Lower Thames Crossing

9.54 Comments on LIRs

Appendix C – Essex County Council

Planning Inspectorate Scheme Ref: TR010032
Examination Document Ref: TR010032/EXAM/9.54

Figure 1. Do Something vs Do Minimum 2030 AM

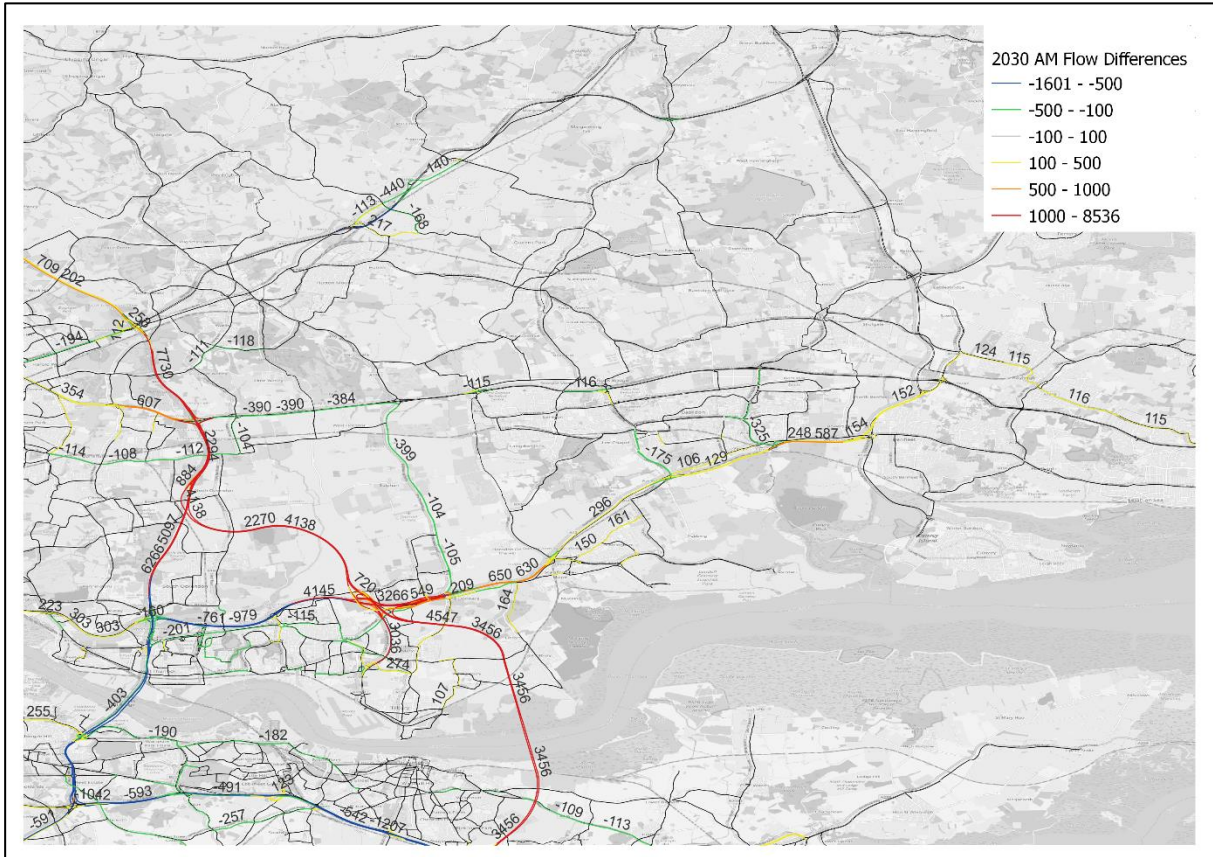
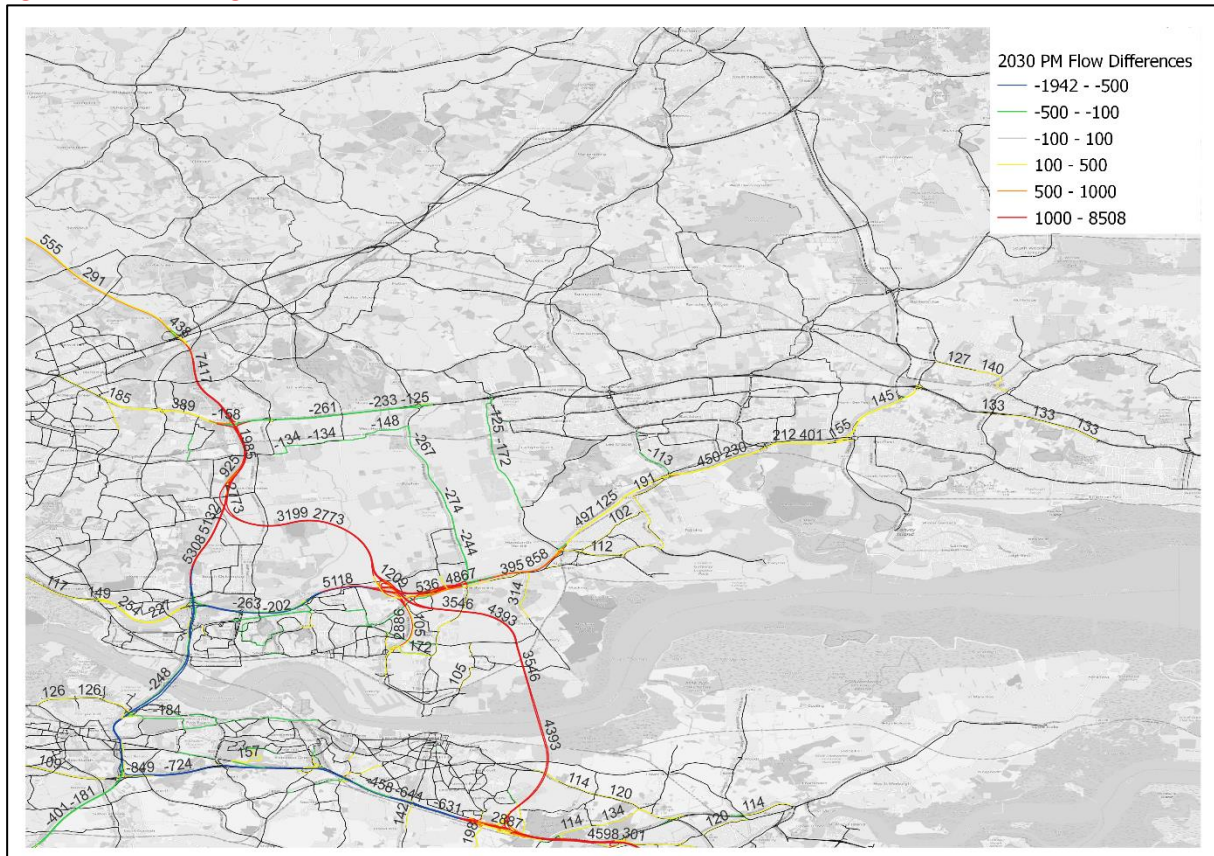
<p>Applicant's Response</p>	<p>This comment is noted.</p>
<p>Page 15-17</p>	<p>Do Something vs Do Minimum 2030</p> <p>The plots in Figure 1 and Figure 2 show the difference in flows in PCUs between the 2030 Do Something and Do Minimum runs.</p> <p>The maps produced for 2030 show that, as would be anticipated, the major changes mostly occur close to the LTC scheme.</p>

LIR Reference	Local Impact Report Extract / Applicant’s Response
	<p>During the AM peak it can be seen that the LTC is resulting in a reduction in traffic along the A13 between the M25 and the LTC of approximately 1,000 PCUs. To the east of the LTC though there is an increase in traffic on the A13 eastbound of approximately 650 PCUs as far as the A1014 junction. The flows to the east of this are still forecast to be higher than without the LTC but reduce as distance increases from the LTC scheme.</p> <p>There is also a reduction in traffic on both the A127 westbound (approaching 400 PCUs) and on the A128 northbound (400 PCUs) as traffic is expected to divert onto the LTC.</p> <p>There are limited changes elsewhere on the network in the AM peak forecast in 2030.</p> <p>During the PM peak the re-routing of traffic is similar, although as would be expected there is some alteration in the directionality of the changes. On the A13, the largest change in flows is westbound from the LTC to the M25 (approximately 1,000 PCUs). The scale of change on the A13 westbound toward the LTC scheme is higher at approximately 500 PCUs in the PM peak.</p> <p>As in the AM peak there is a reduction in traffic expected in the PM peak on the A127 and A128, albeit eastbound on the A127 (-280 PCUs) and southbound in the A128 (-270 PCUs).</p> <p>In summary, the flow difference analysis indicates that major change to traffic flows in or near Essex will be largely constrained to the main A13 and M25 corridors.</p>

Applicant’s Response	<p>This comment is noted.</p> <p>On many roads to the west of the Project, such as the A2, the A13, the Dartford Crossing and the M25 in Thurrock, the number of vehicles would fall when the Project opens. However, roads on the approach to the Project, including the M2, A228, A229, and some roads to the east of the Project, such as the A13, the A2 and some sections of the M25, would experience an increase in traffic levels as travel across the River Thames becomes easier and more reliable. The changes in traffic flows across the region are detailed in full in Chapter 7 of the Transport Assessment [APP-529]. Overall, the benefits on the road network outweigh the adverse impacts, and this is reflected in the positive economic benefit of the Project.</p>
Page 18-19	<p>Do Something versus Do Minimum 2045</p> <p>Figure 3 and Figure 4 show the changes in flows for 2045 for the do something model scenario compared to the Do Minimum. As with the 2030 opening year, the 2045 forecast year shows very similar trends in flow changes between the two different “do something” scenarios.</p> <p>In the AM peak, there is a reduction in expected flows westbound from the LTC towards the M25 of more than 1,000 PCUs and a reduction of 800 PCUs eastbound. To the east of the LTC, flows on the A13 increase by approximately 600 PCUs in both directions as far as the A1013 junction.</p>
